22 August 2019

**RE: SSD 9670 Response to Submissions  
Western Sydney University Innovation Hub, 2-6 Hassall Street, Parramatta**

2 SECTION 1 | TIMBER DECK AND MASS PLANTING  
1:25

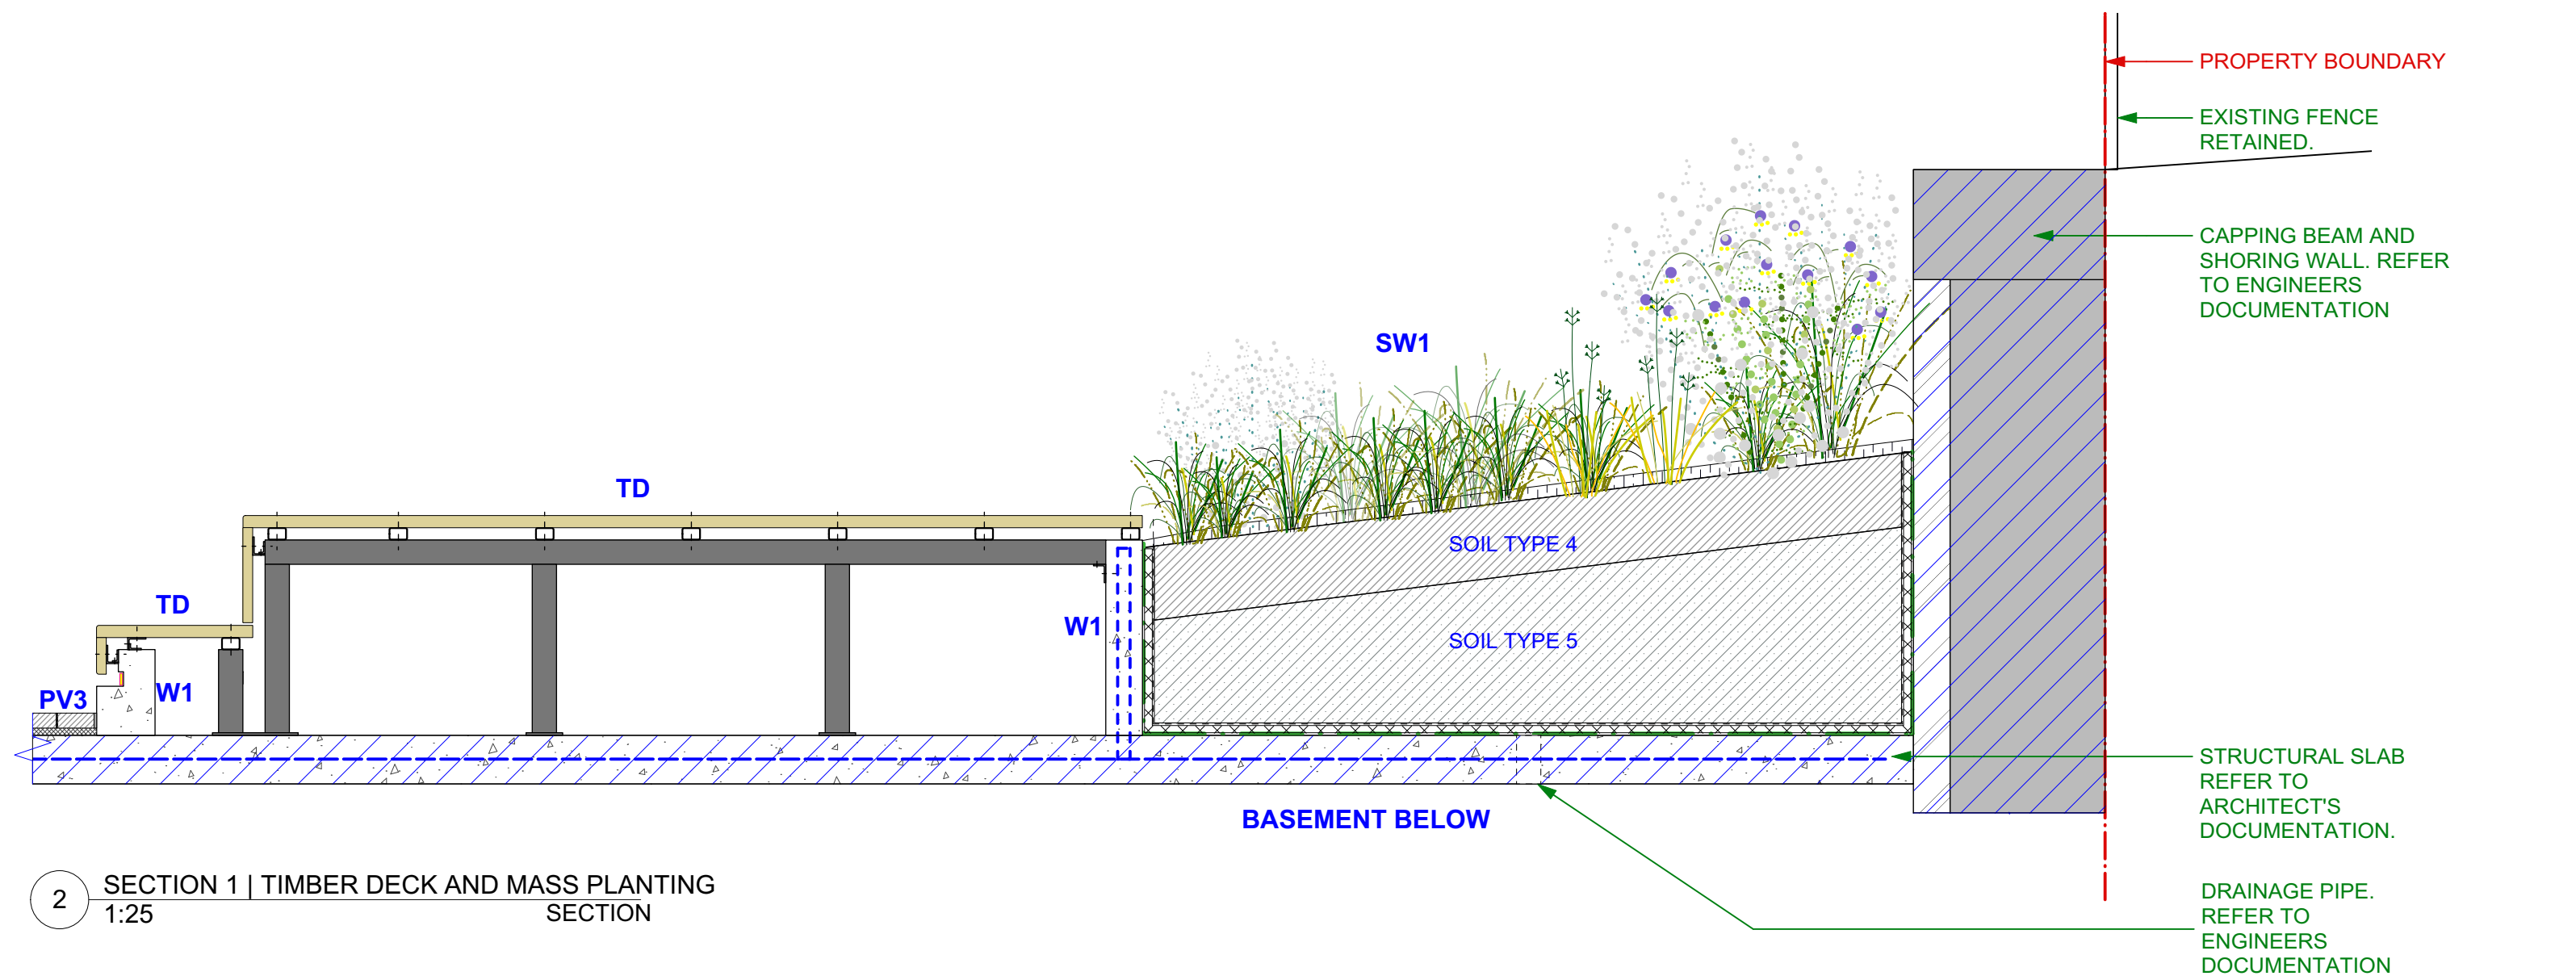
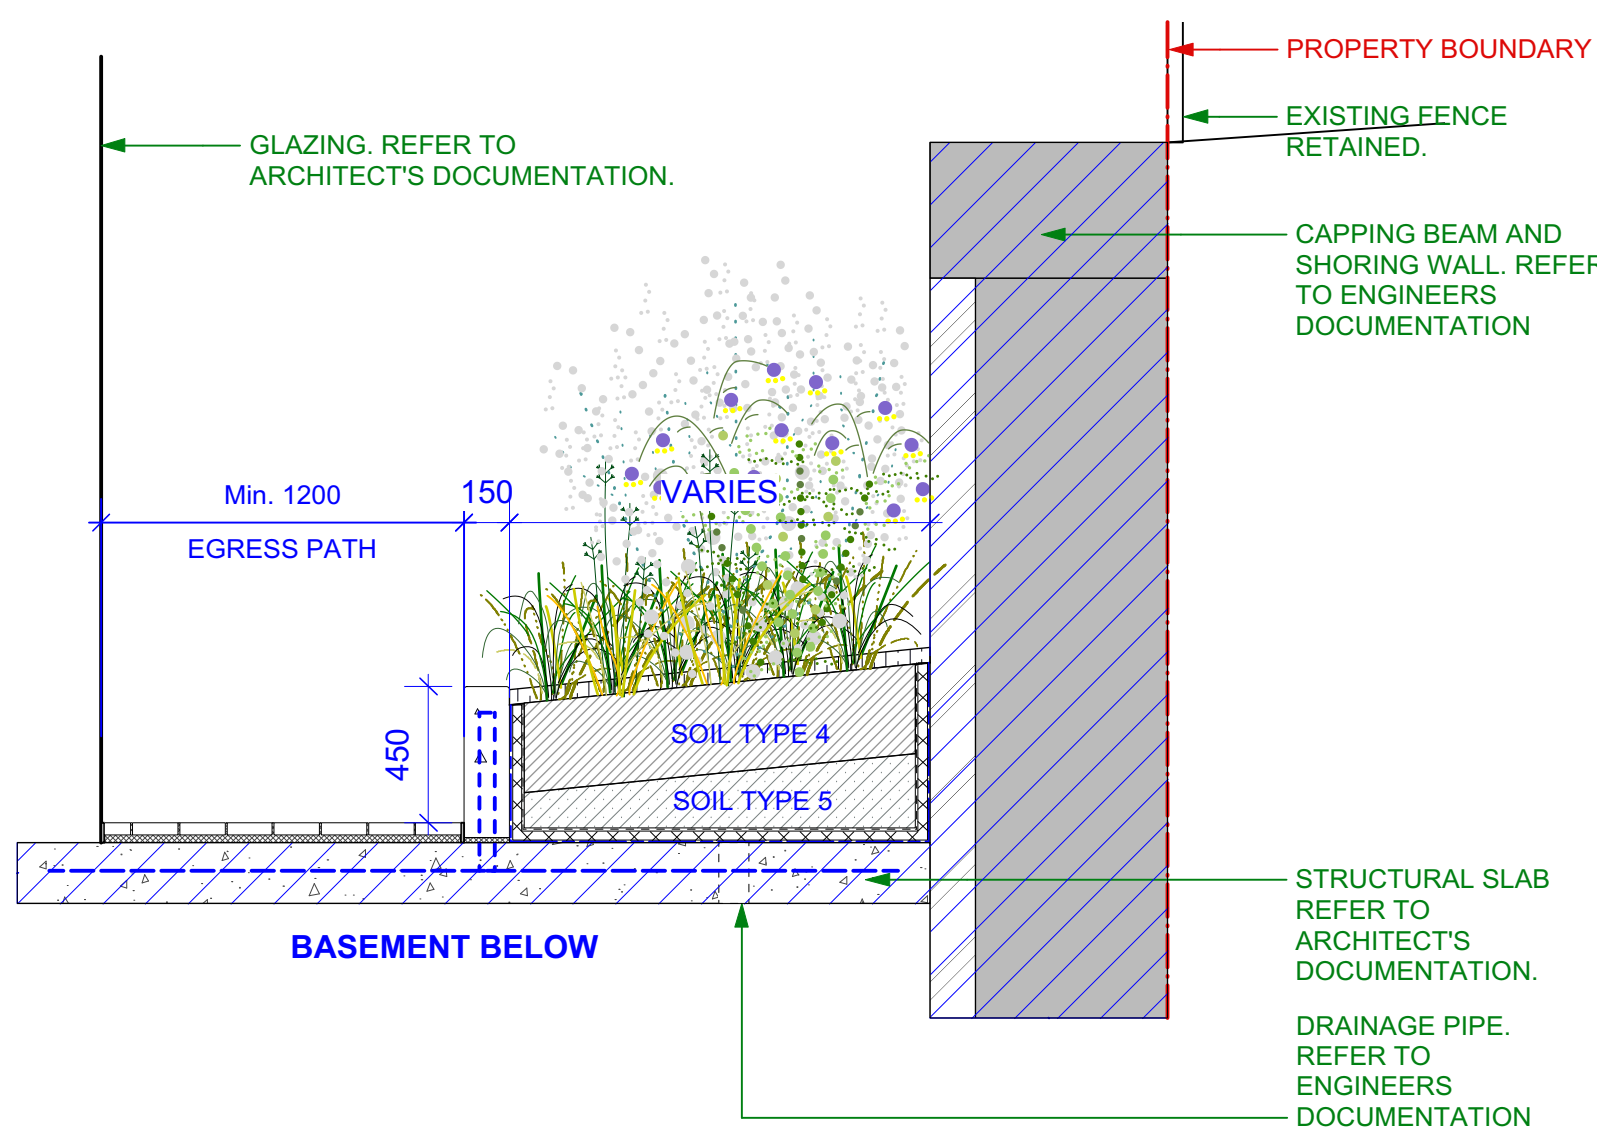
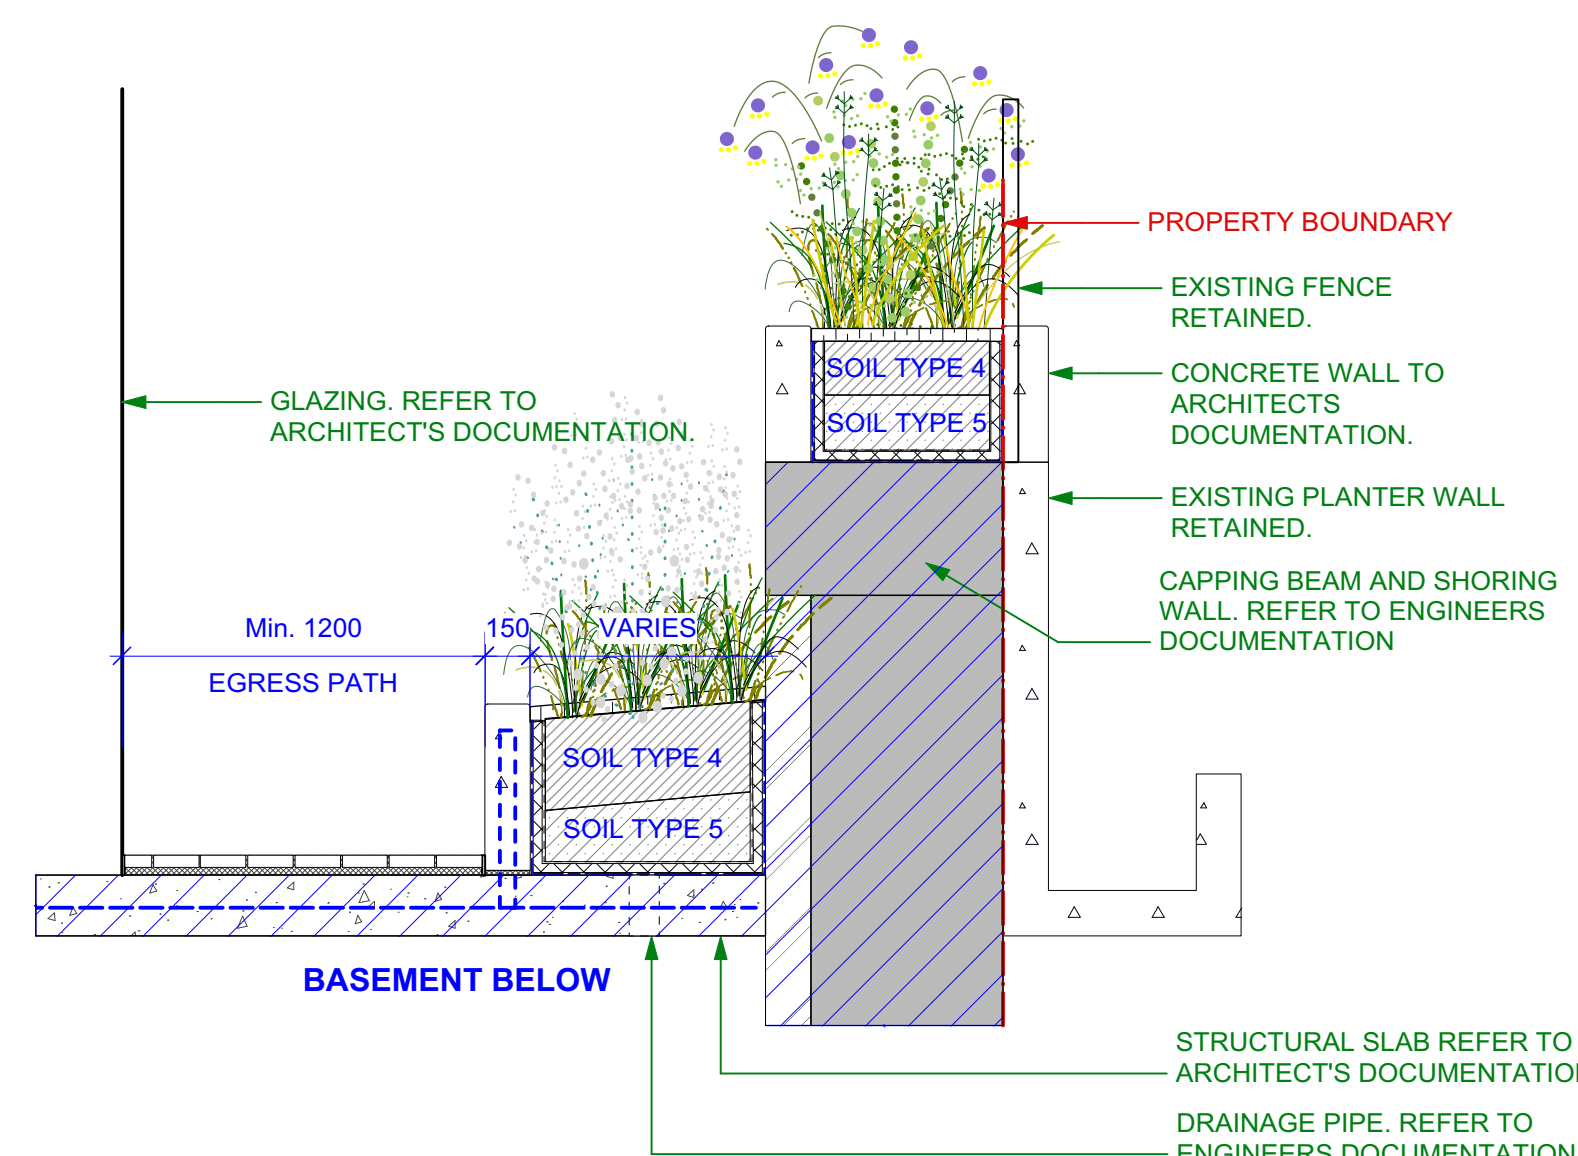
Council has requested that further information be provided on how the potential future through site link to the Lancer Barracks could work, with design options and levels to be provided.

The design as lodged at the Lancer Barracks interface included a landscaped area providing a transition to the Lancer Barracks boundary. Fronting this landscaped area, was a set of angled stairs which would serve as a breakout space for students and office workers utilising the plaza and retail areas, designed to be easily adapted in the event that the Lancer Barracks is released as public open space in the future.

In order to provide further flexibility, the design of these northern stairs / breakout space has been further refined, as described in **Section 2.0**, and shown in **Figure 1**. The design allows adaptation for a DDA compliant ramp traversing both the subject site and the Lancer Barracks, as shown in **Figure 2**. This option retains and integrates

the proposed stairs with the DDA design, retains the proposed timber decking, and retains the potential for mass planting and feature trees between ramps.

The design shown in **Figure 2** represents one of a number of potential design options which the proposed rear decking area could accommodate. Any future design linking into the Lancer Barracks will be subject to further consultation should the Lancer Barracks be repurposed, or should there be an appetite in the short to medium term to provide a pedestrian link over the Barracks landholdings.
